# CITY OF ALBUQUERQUE

**Re: Dutch Bros Coffee**  
**10001 Central Ave NE**  
**Request for Certificate of Occupancy- 30 Day Temp**  
**Transportation Development Final Inspection**  
Plan Approval Date 2-15-23 (L20D048)  
Certification dated 1-27-24

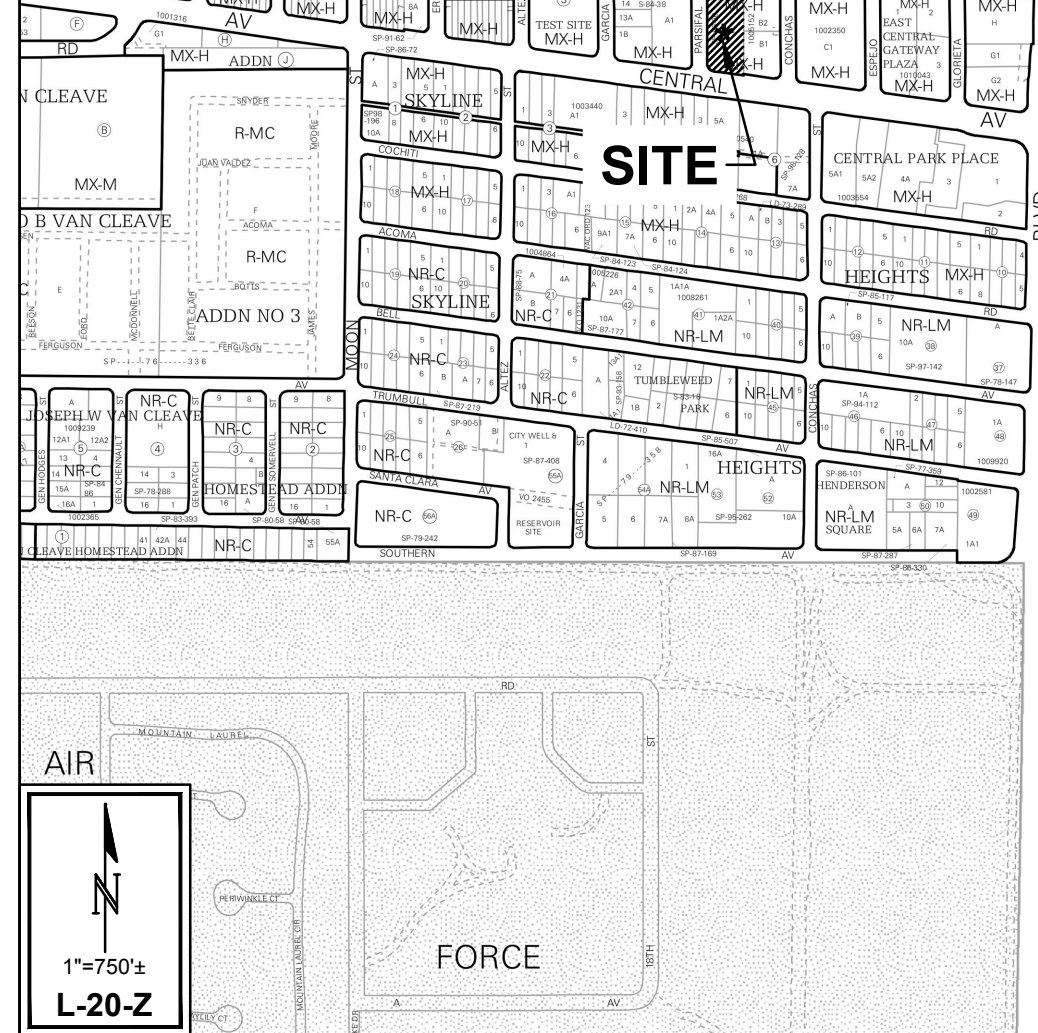
1. Two sidewalk stones along Parsifal St. are to be replaced: one is broken just south of the entrance and the other is a trip hazard and is broken just north of the sidewalk culvert. The stones were shown to the Superintendent.
2. The Pubic ramp at the southwest corner of the site is only 43" wide. City Specifications specify a minimum of 5' wide, however, the DPM allows for 4' wide. It appears there is room to widen the ramp/pedestrian path to 4'. Please let me know if you think the location of the light pole and fire hydrant do not allow the ramp/pedestrian path to be widened to 4'. In addition, the ramp may function better if it were pointed more to the west.
